Response to Submission comments for Parramatta Leagues Club Hotel (SSD-8800)

Thank you for your referral inviting comments from the Heritage Council of NSW on the above State Significant Development (SSD), Response to Submissions. I note that the Peer Review Report of the Statement of the Heritage and Visual Impact Assessment for the above mentioned development was forwarded to the Heritage Council on 21 February 2021.

DRAWING TITLE
GA ELEVATION - PARRAMATTA LEAGUES CLUB -
NORTH-EAST

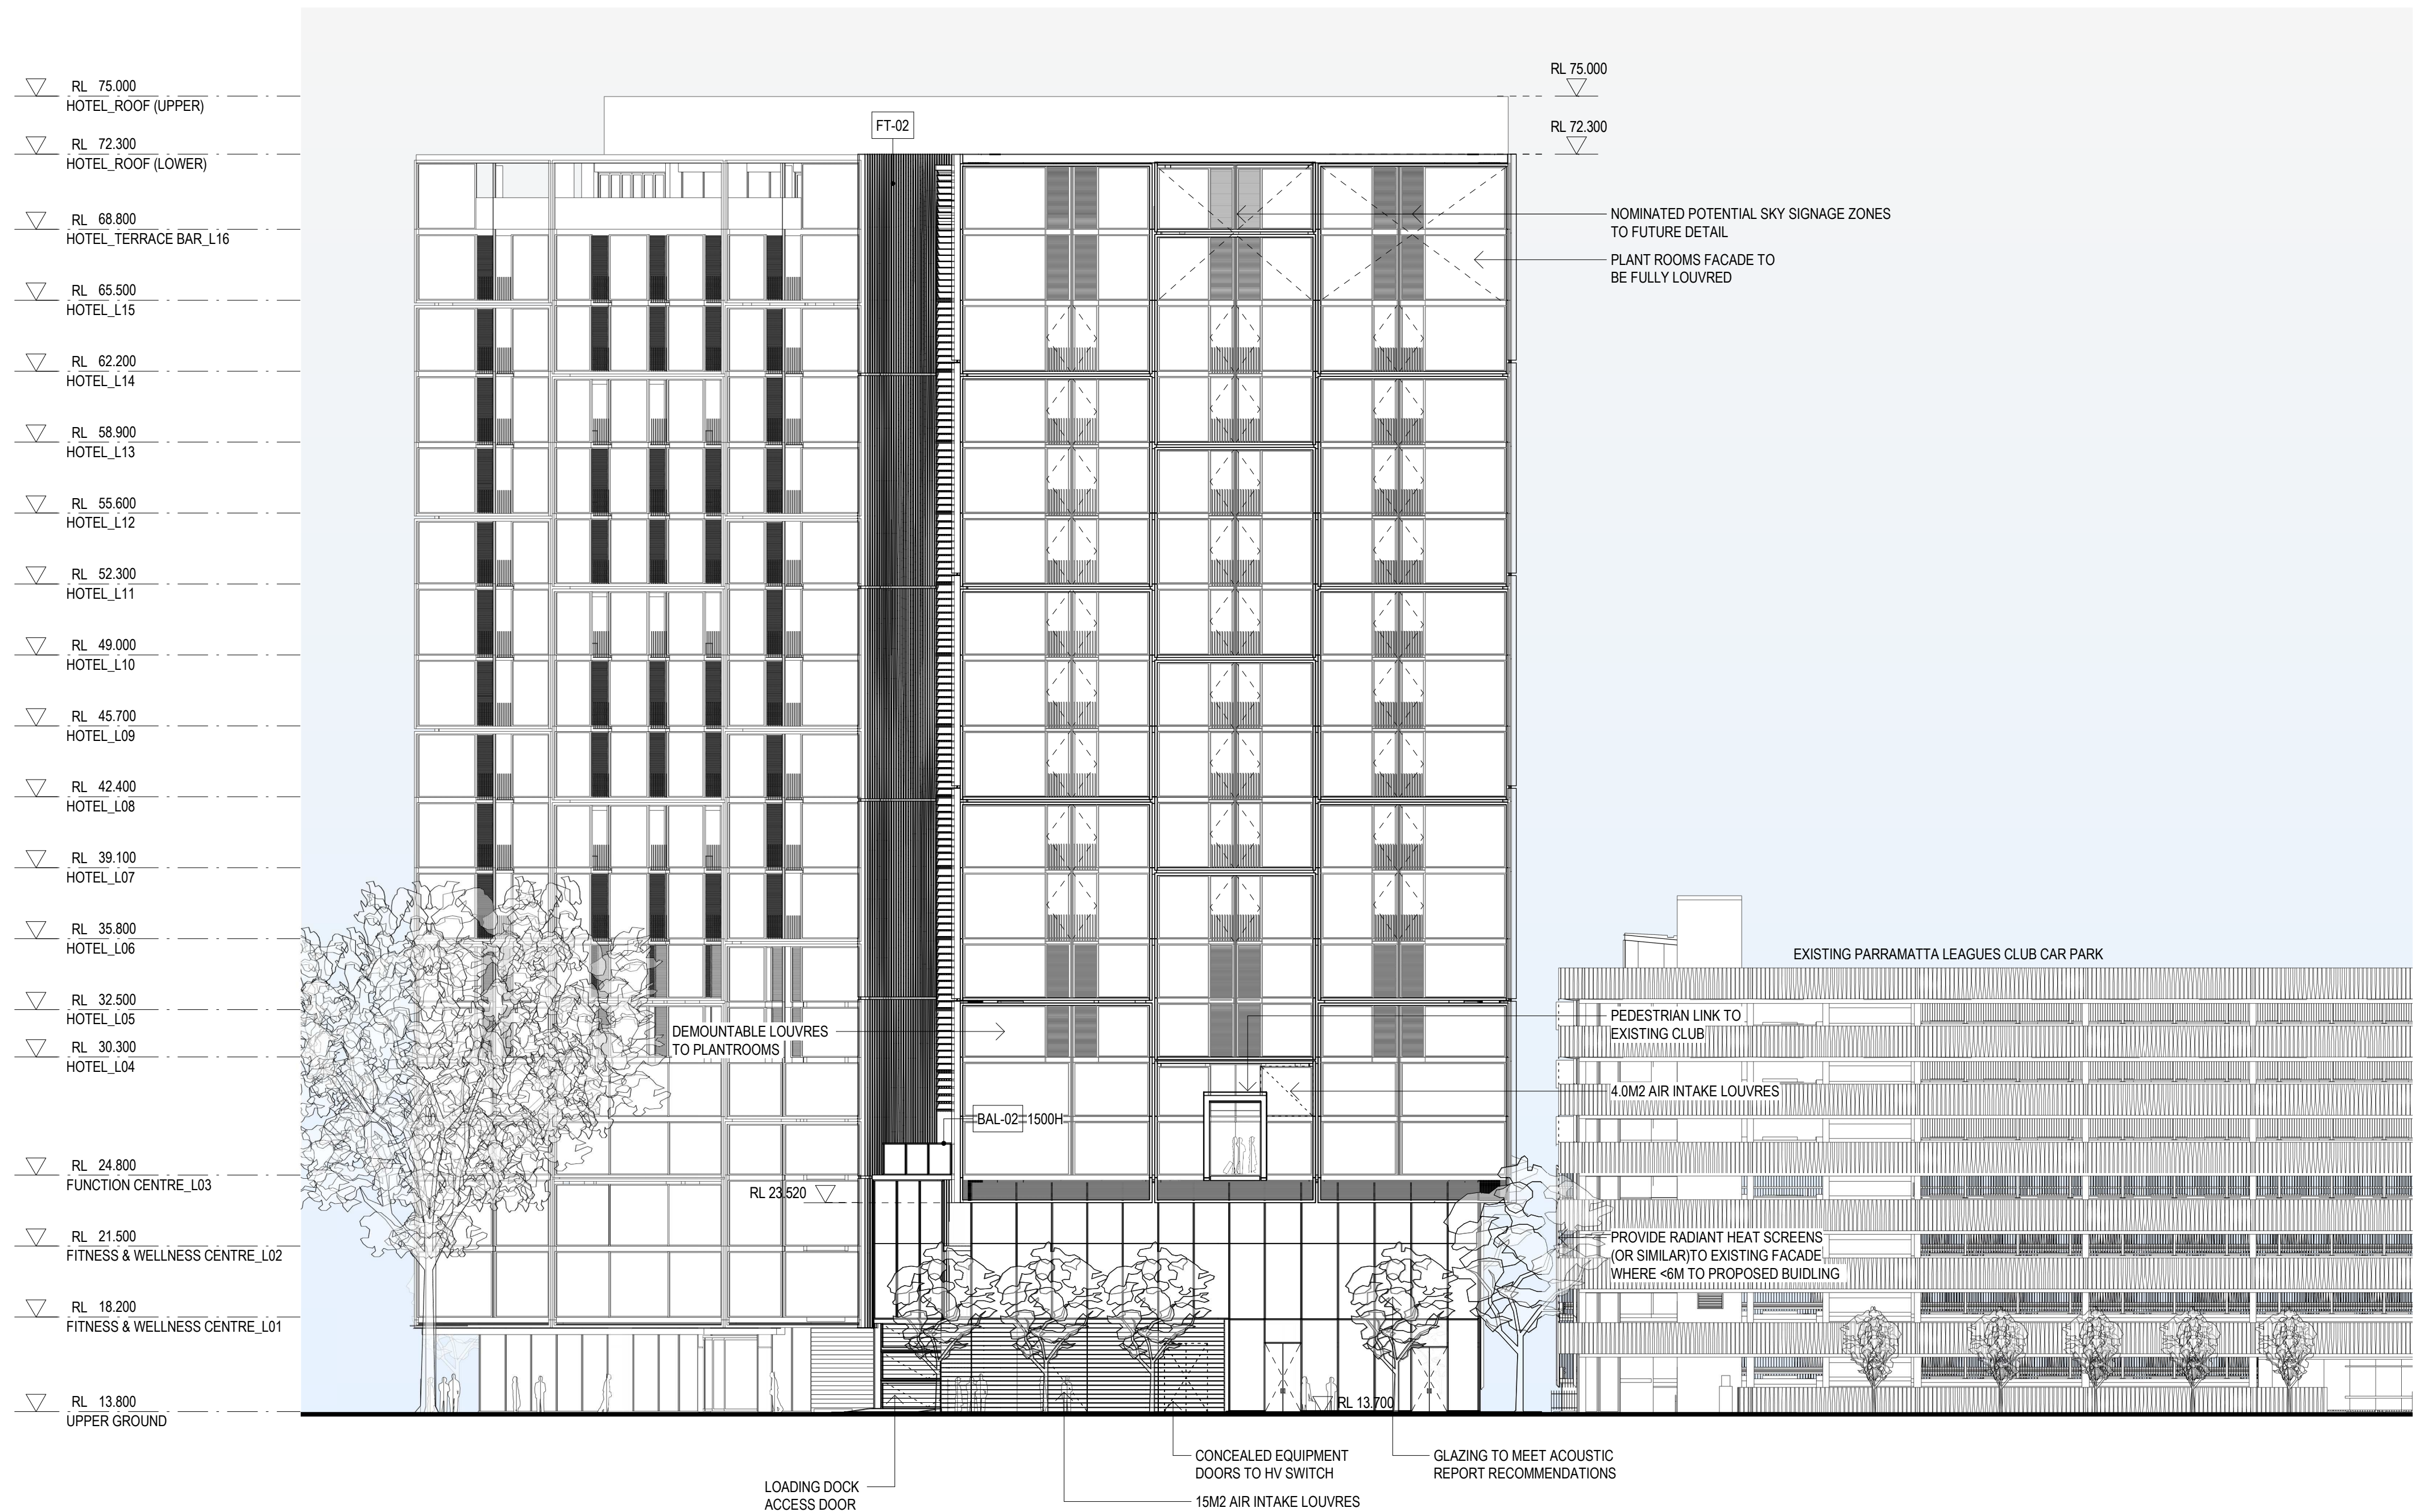
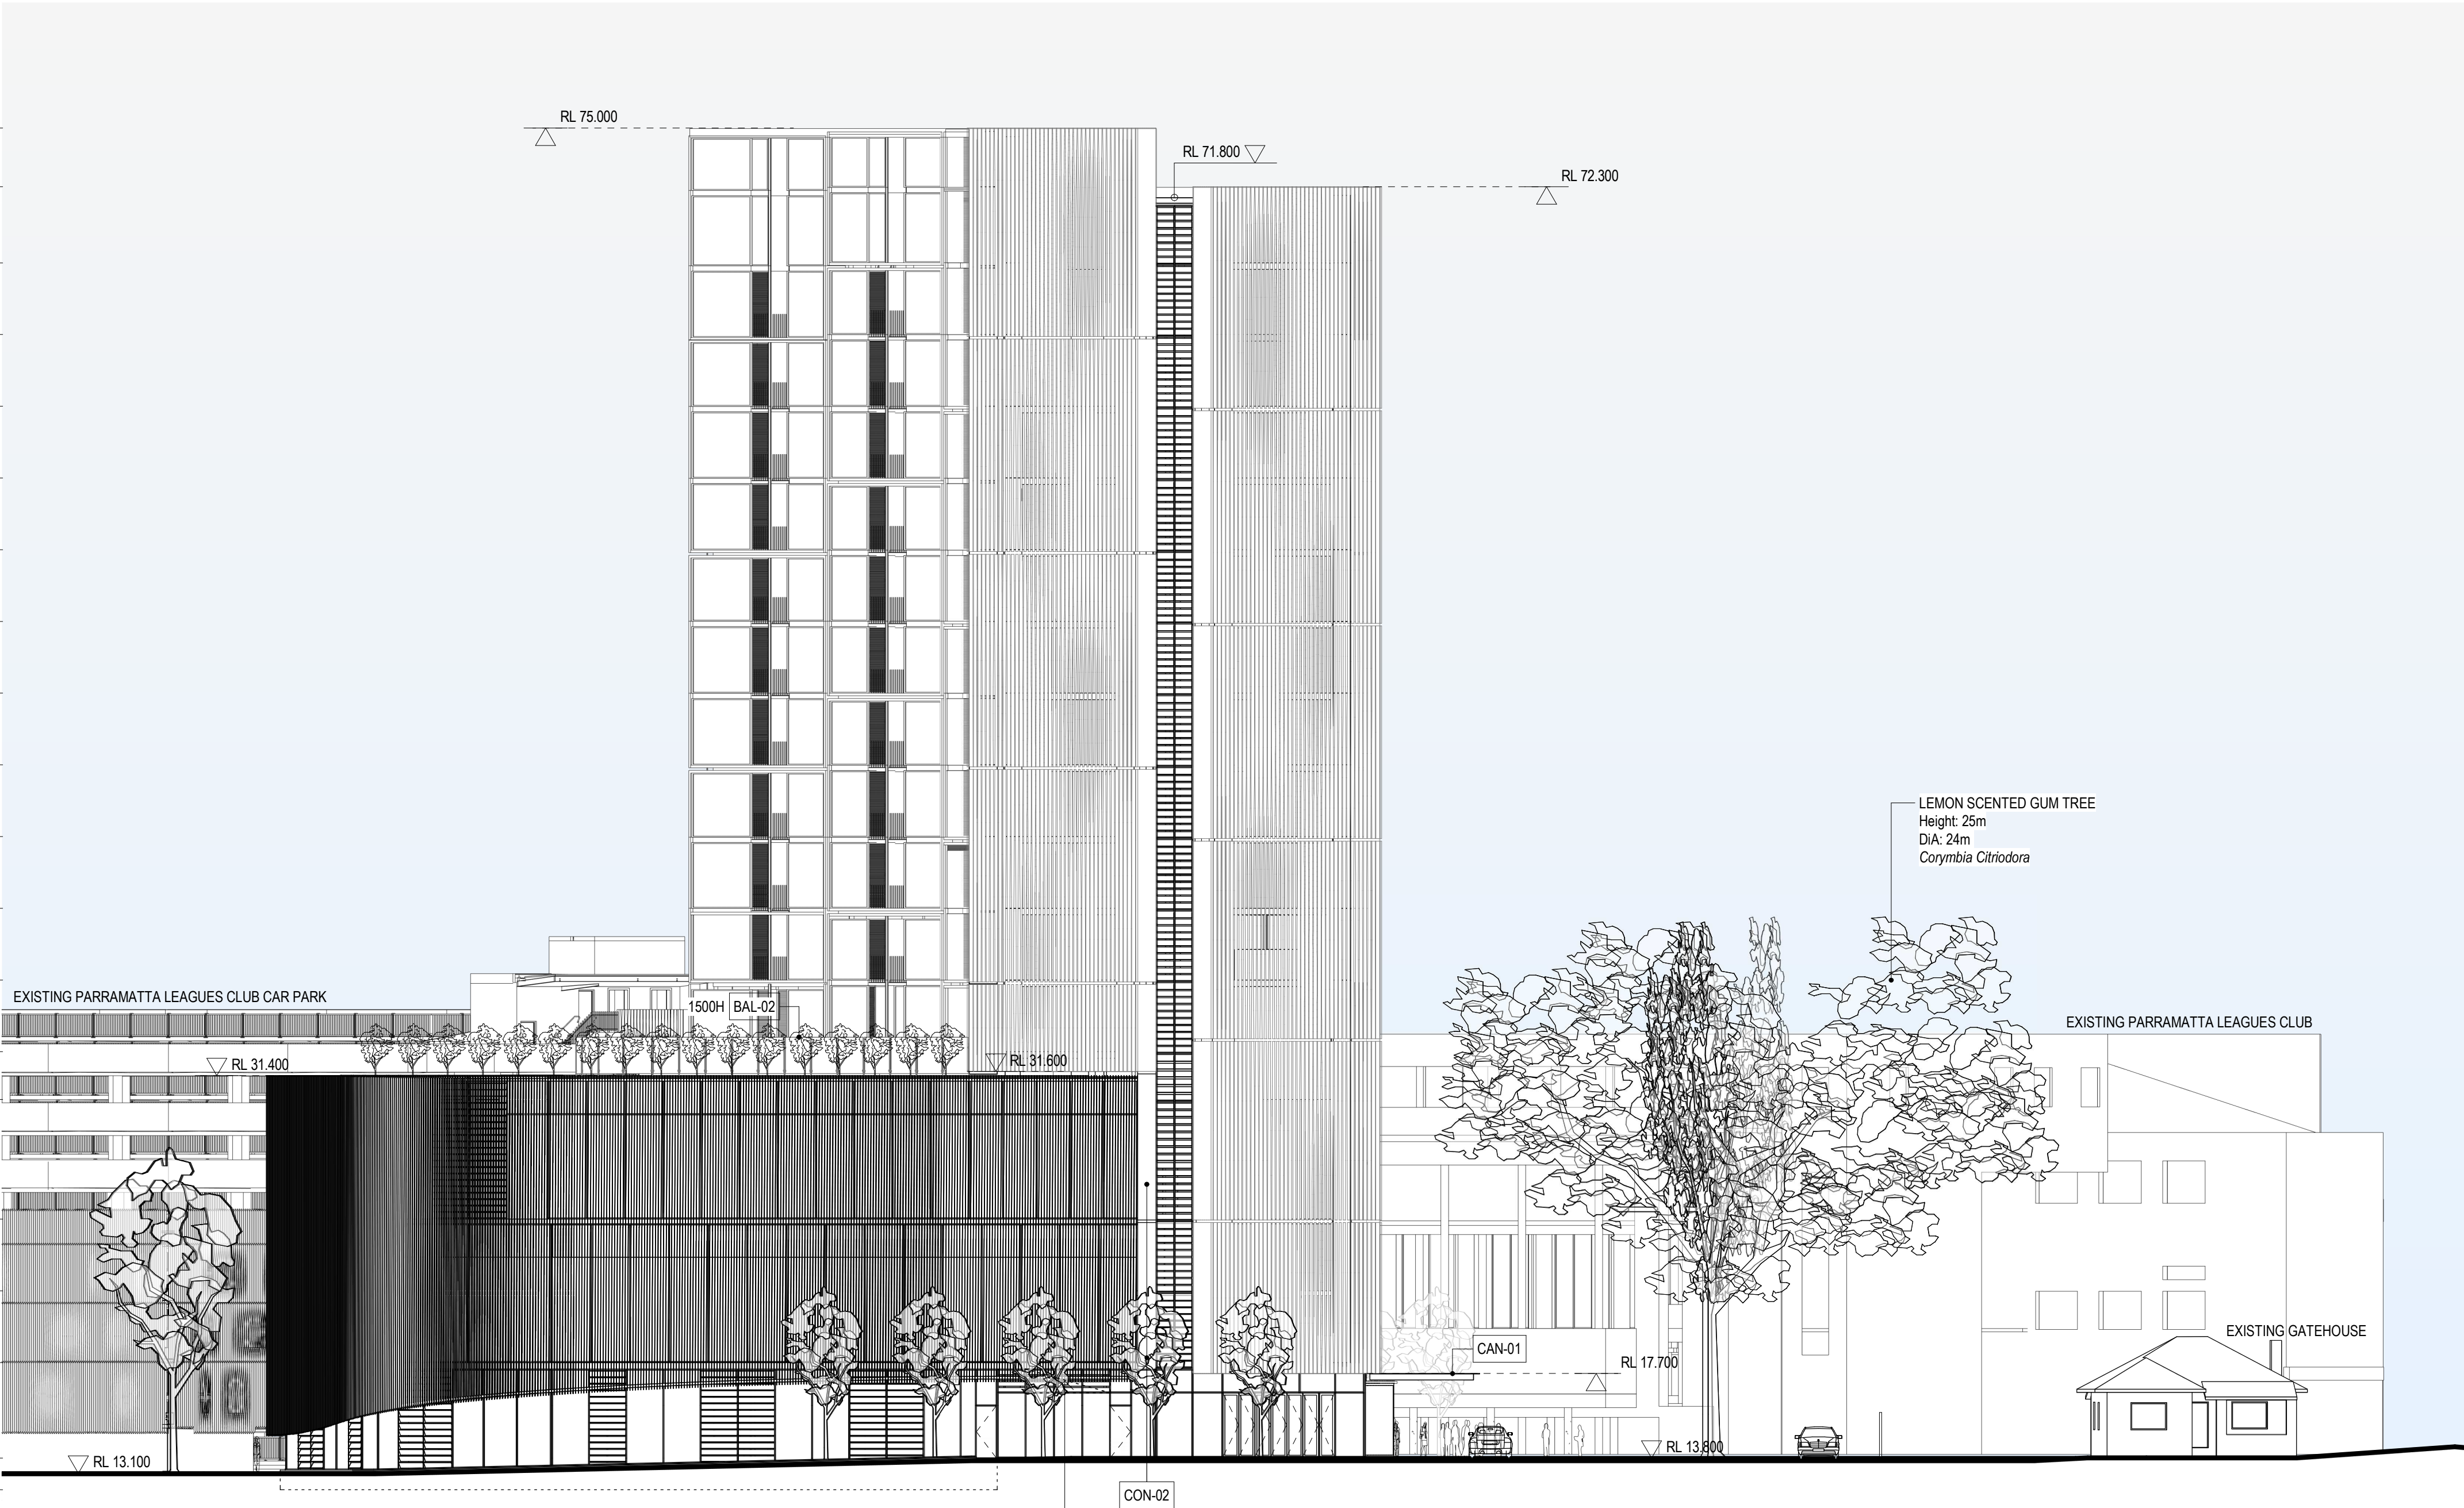
Visual Impacts: The Heritage Council does not support the height of the proposed high-rise tower.

It is noted that the height of the proposed tower has been reduced by 6m, however, it remains substantially higher than the newly built Western Sydney Stadium.

Therefore, the earlier concerns raised regarding the visual impact of the proposed development on the items of State, National and World heritage significance remains, and the previous recommendation requiring the high-rise tower component of the current proposal to be limited to a maximum height no more than the adjacent new Western Sydney Stadium (understood to be approximately of height 42m RL) is reiterated.
